24/21/A/PL

Application for removal or variation of a condition following grant of planning permission.

DEVELOPMENT: LUV TREATMENT BUILDING AND ASSOCIATED UPGRADE FACILITIES
(EG/22/15/PL - 20TH MARCH 2015)

EASTERGATE
UV REACTOR BUILDING
EXTERNAL VIEWS

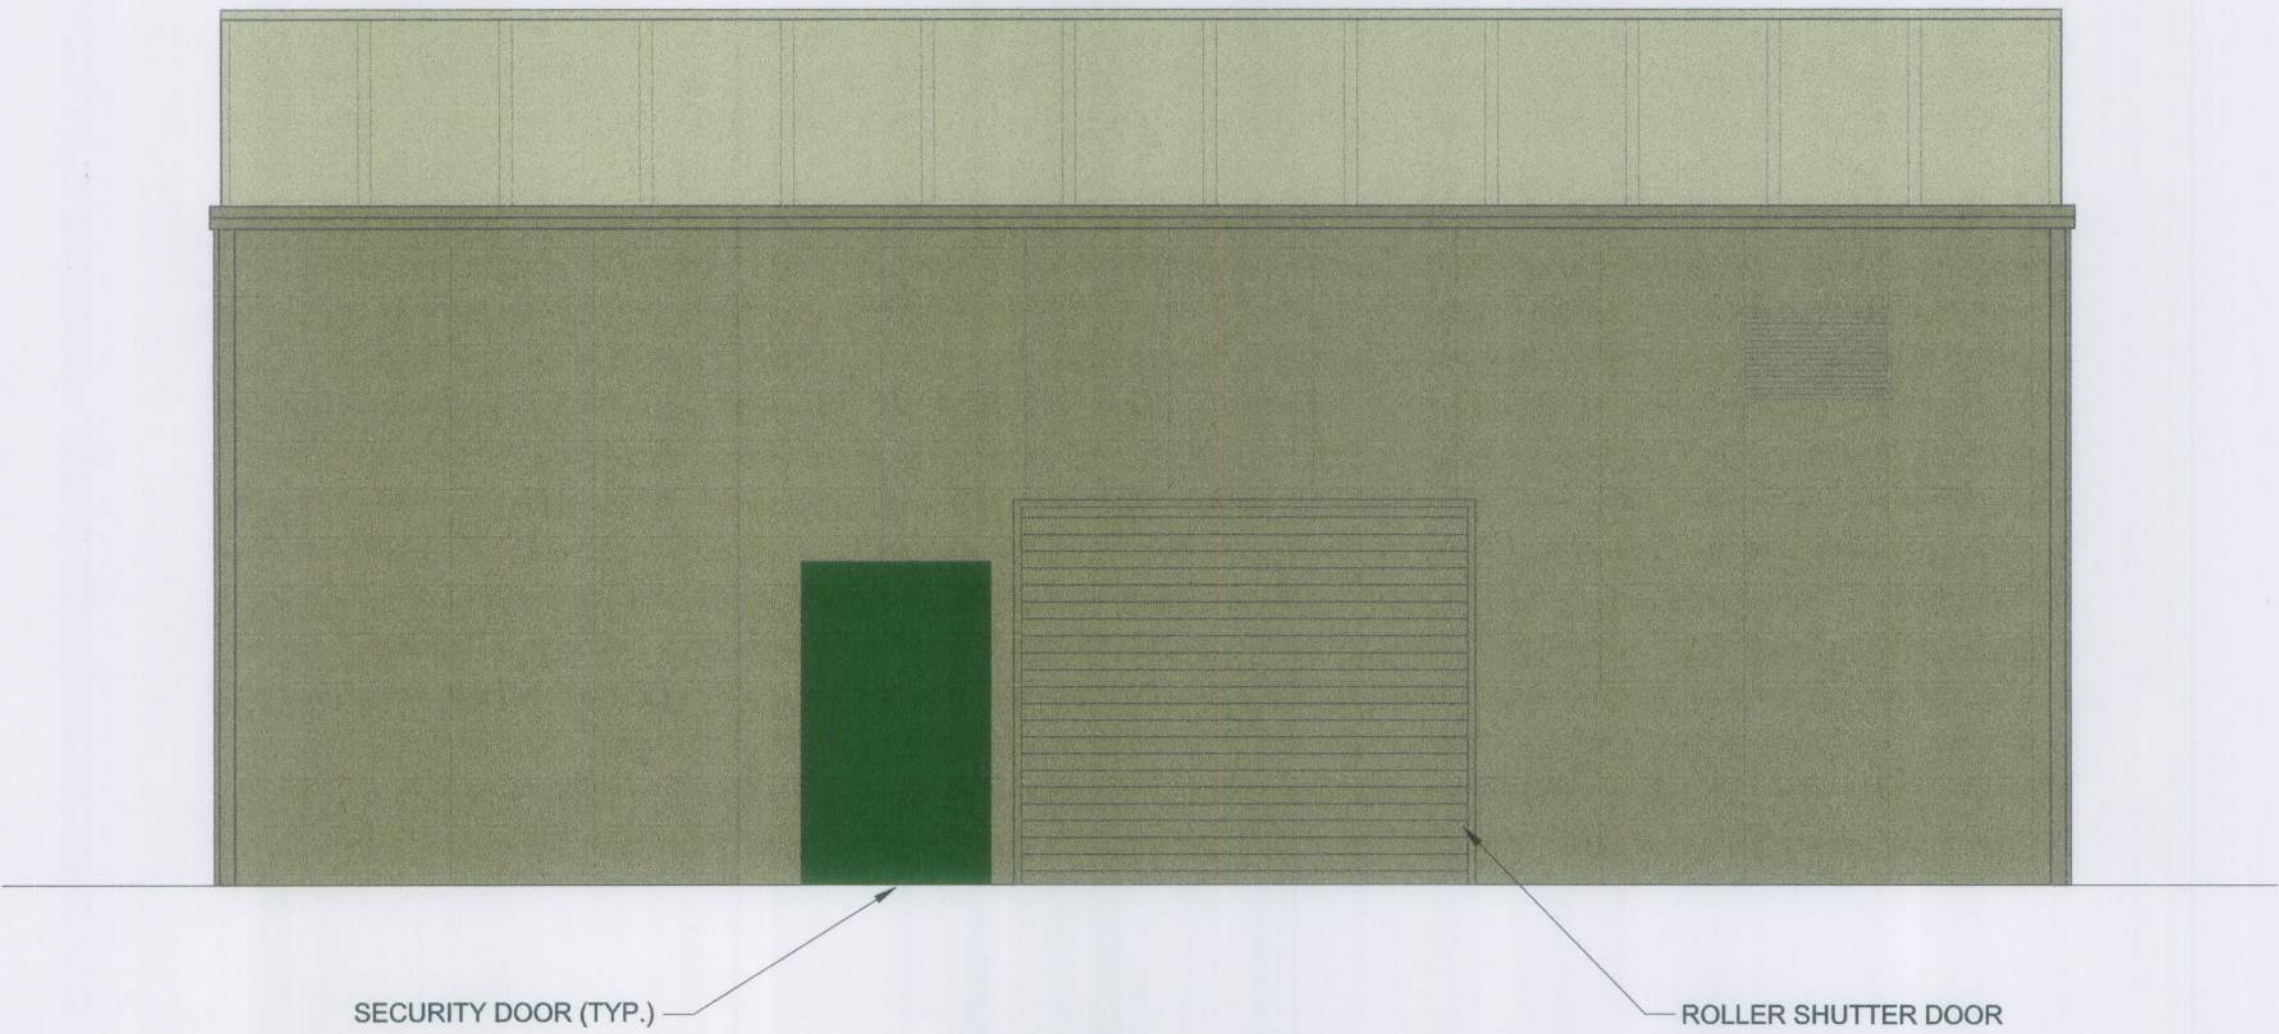
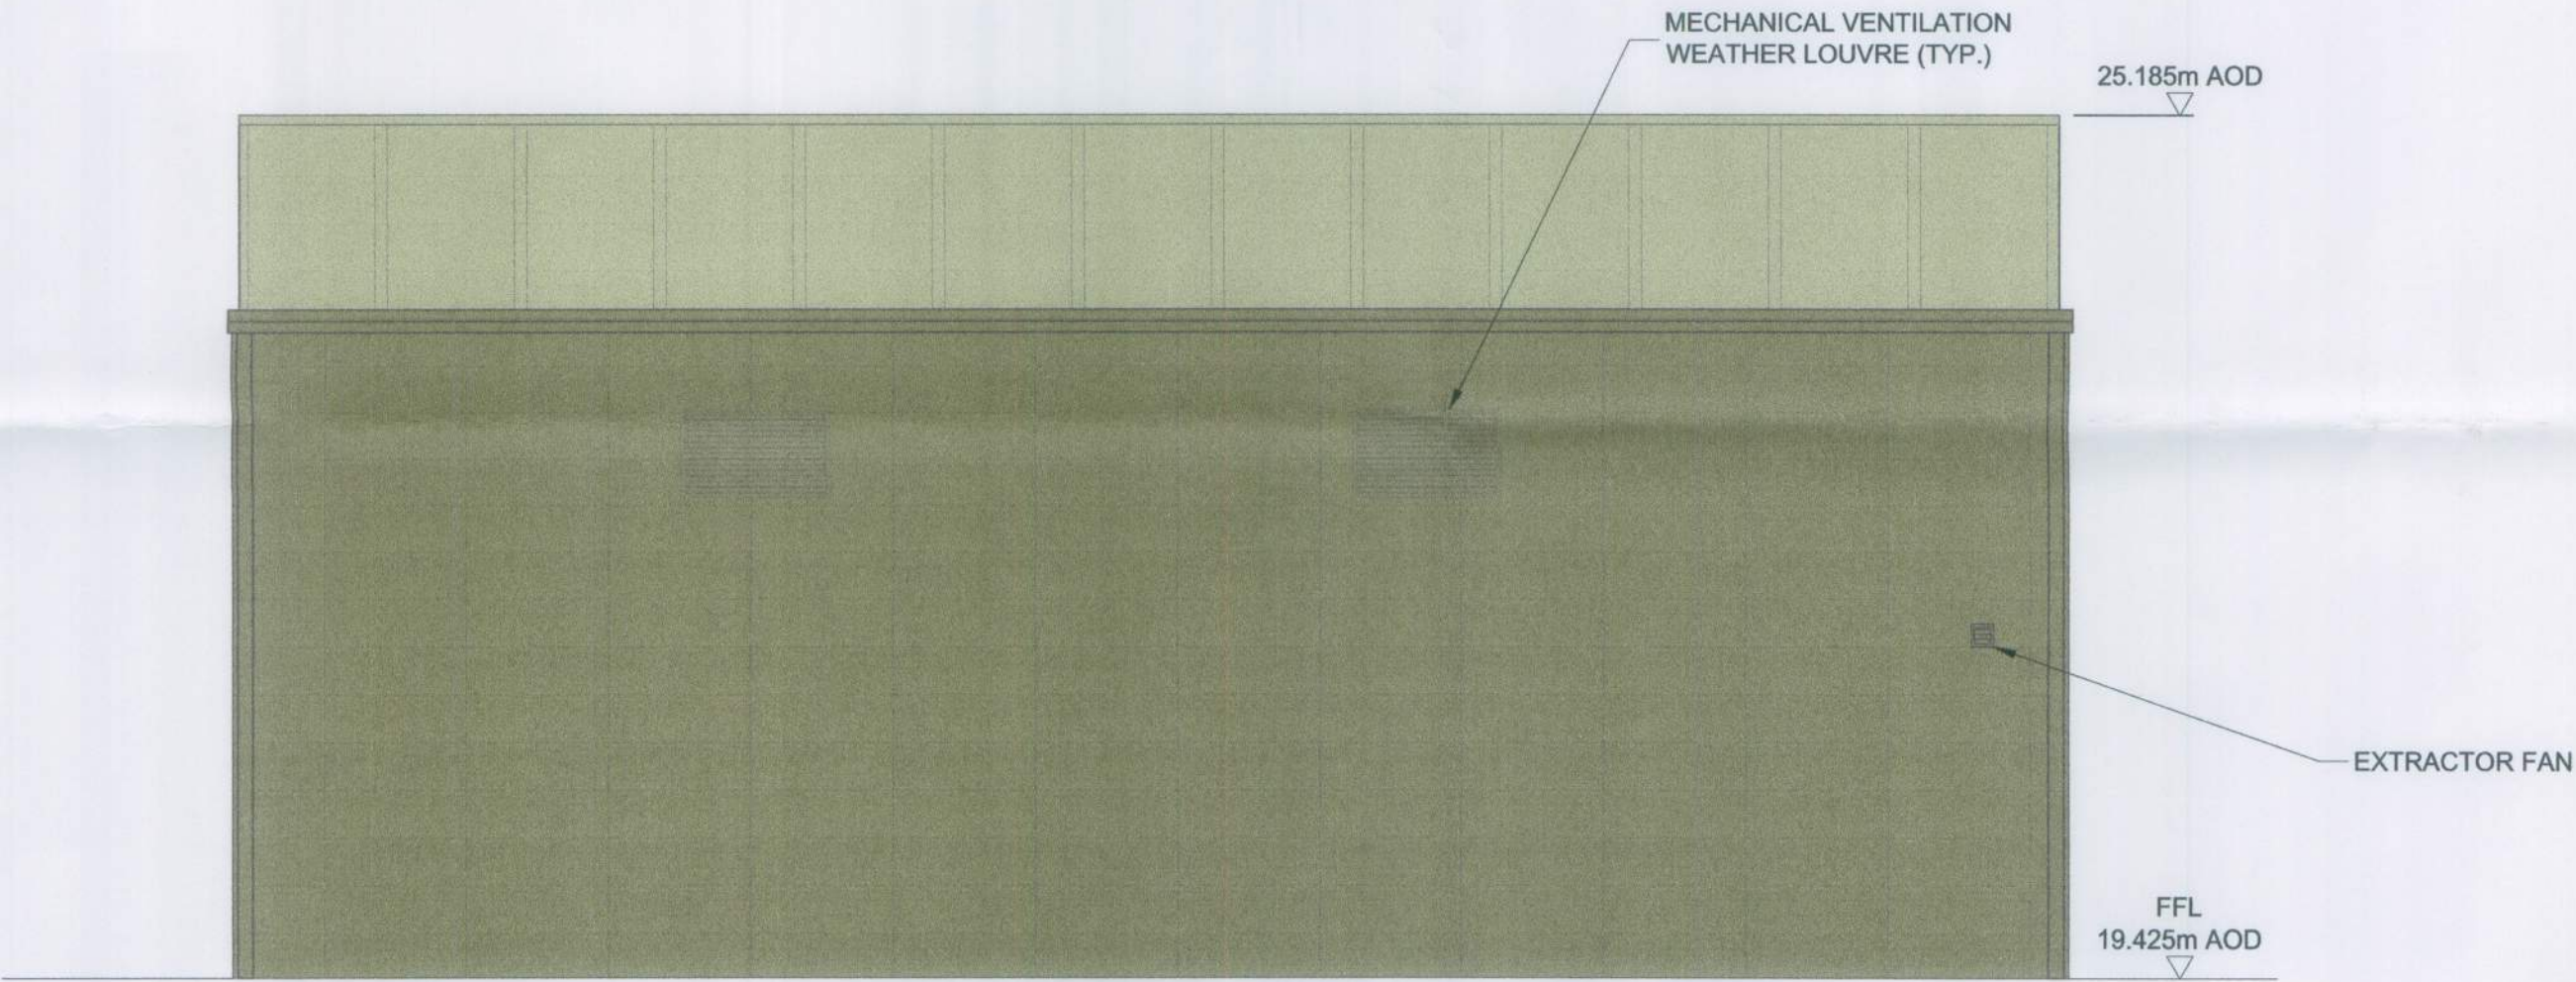
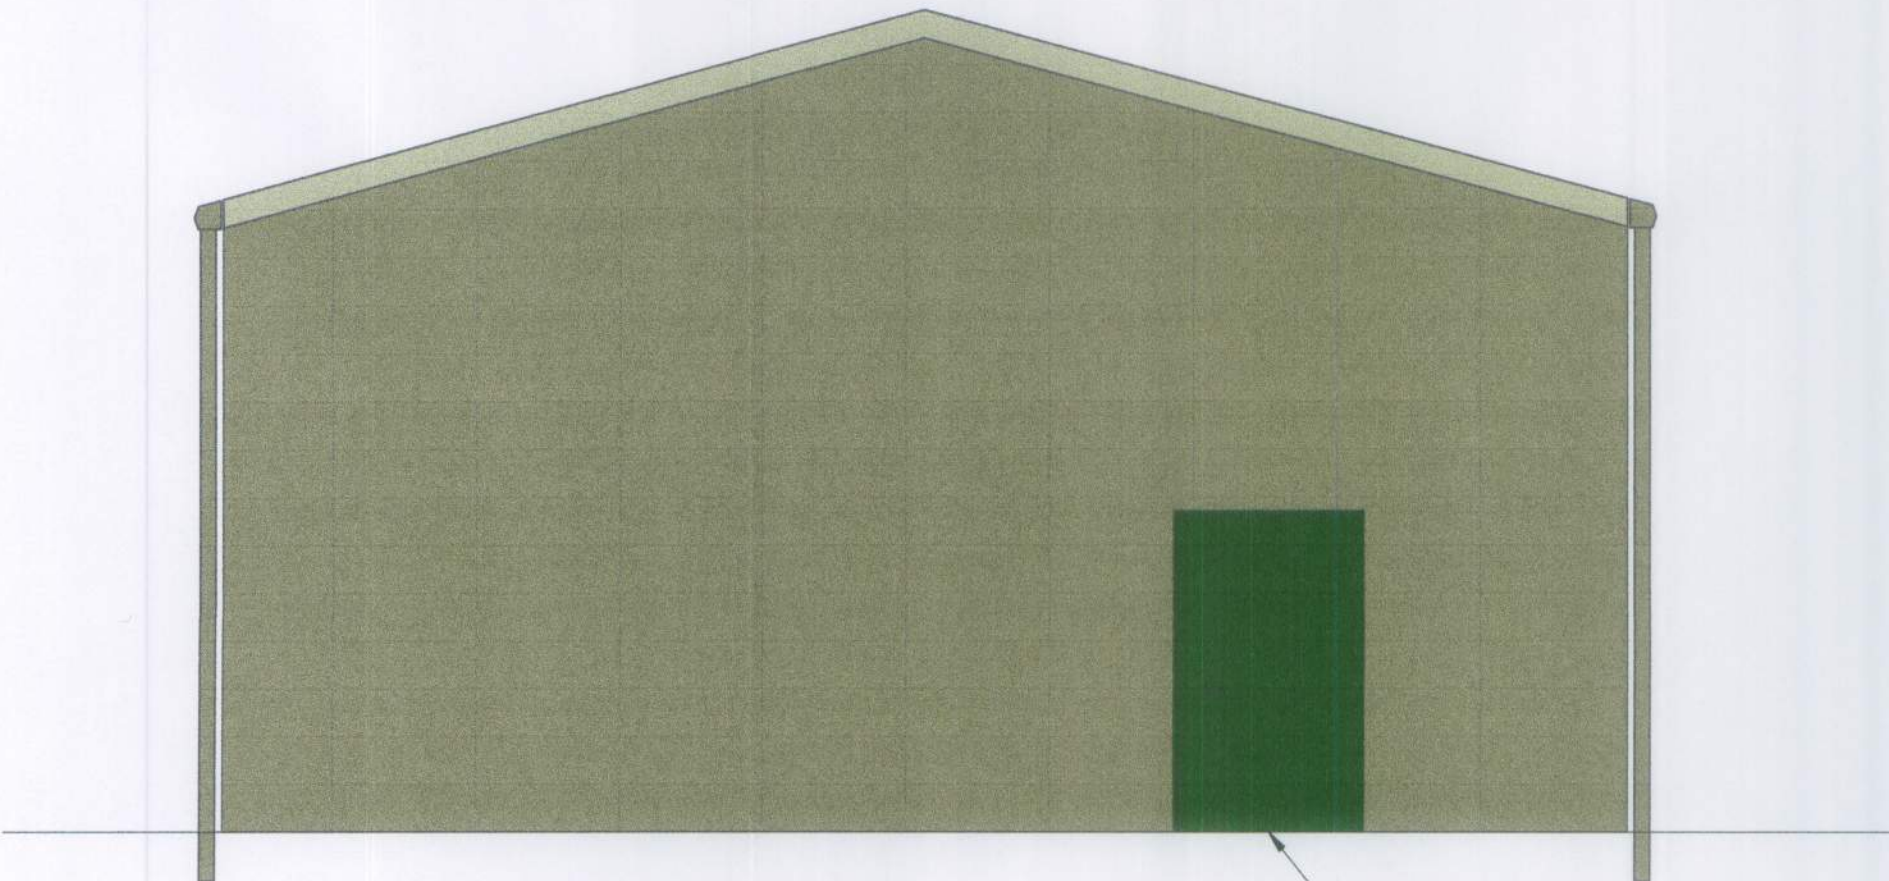
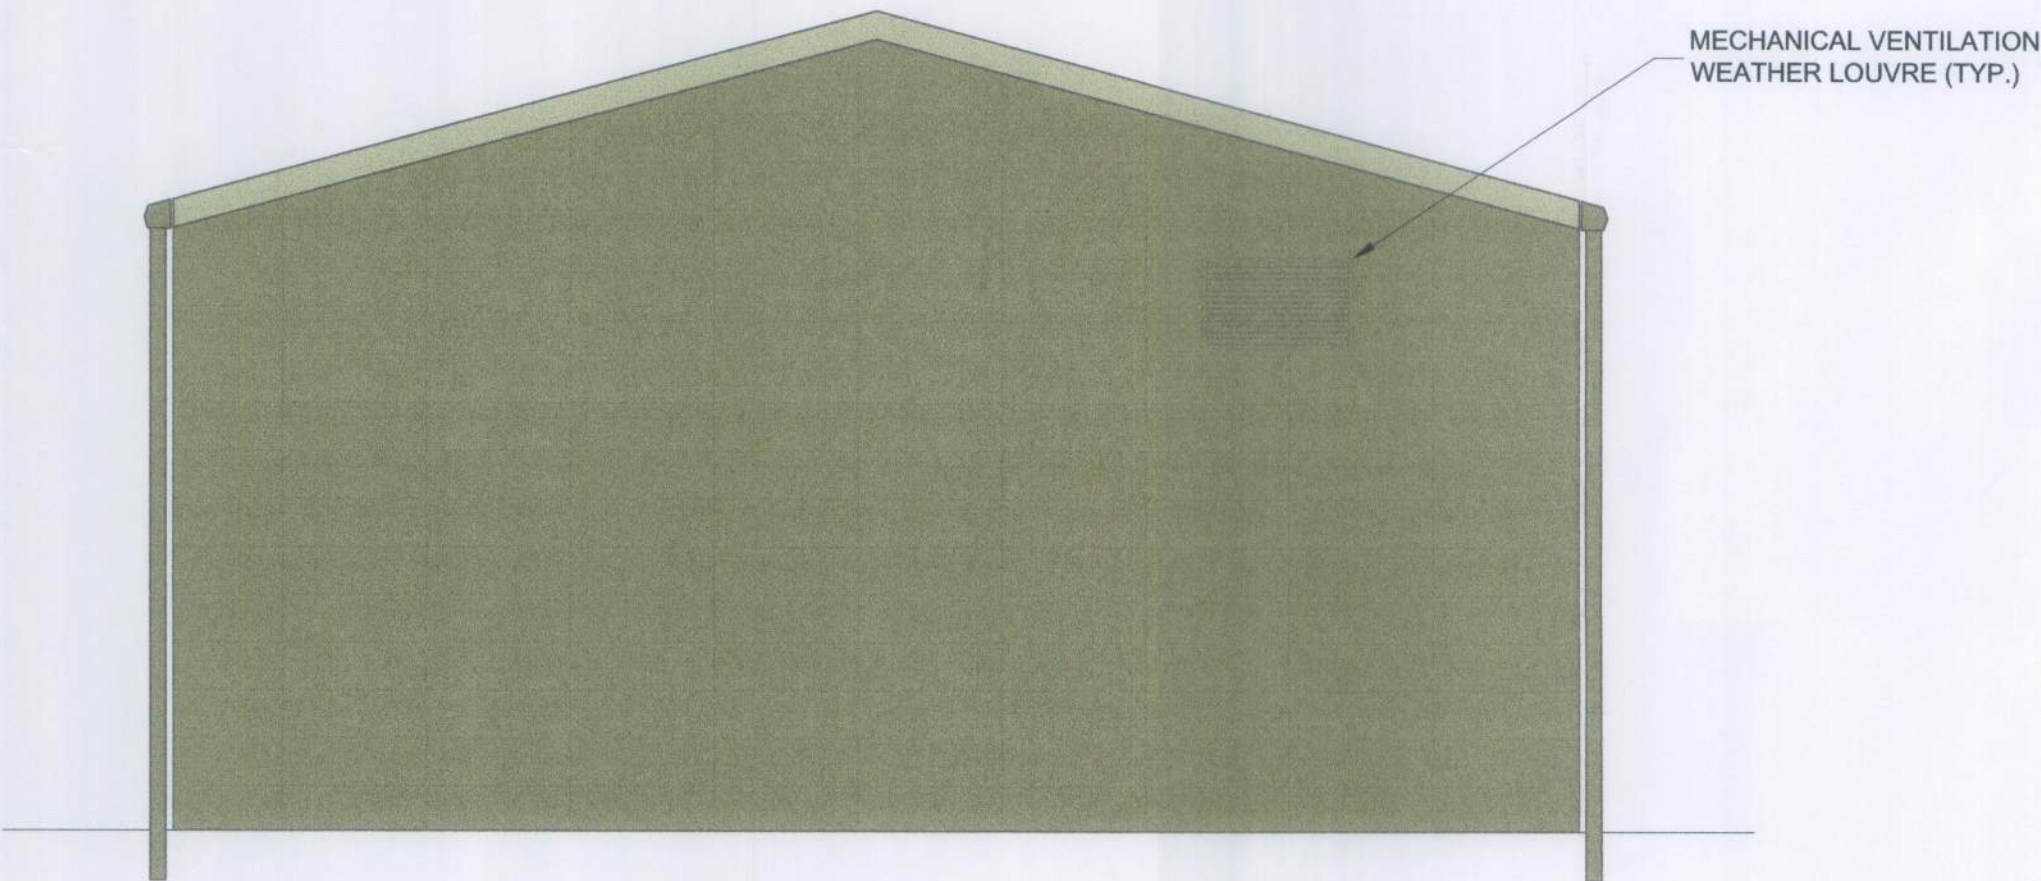
COLOURS SHOWN ON DRAWING 27-5132600-031 REVAL ARE INCORRECT. WE WISH TO CHANGE THE COLOURS AS INDICATED BELOW. ROAD LAYOUT HAS BEEN ALTERED. NEW LANDSCAPE & DRAINAGE DETAILS TO REFLECT SITE REQUIREMENTS

ROOF COLOUR TO BE WILLow GREEN (BS 12 B17, RAL 100 B020); WALL COLOUR TO BE KHAKI GREEN (BS 12 B21, RAL 100 G020); DOORS COLOUR TO BE LEAF GREEN (RAL 6002), HENCE DRAWINGS UNDER CONDITION 2, DRAINAGE CONDITION 3
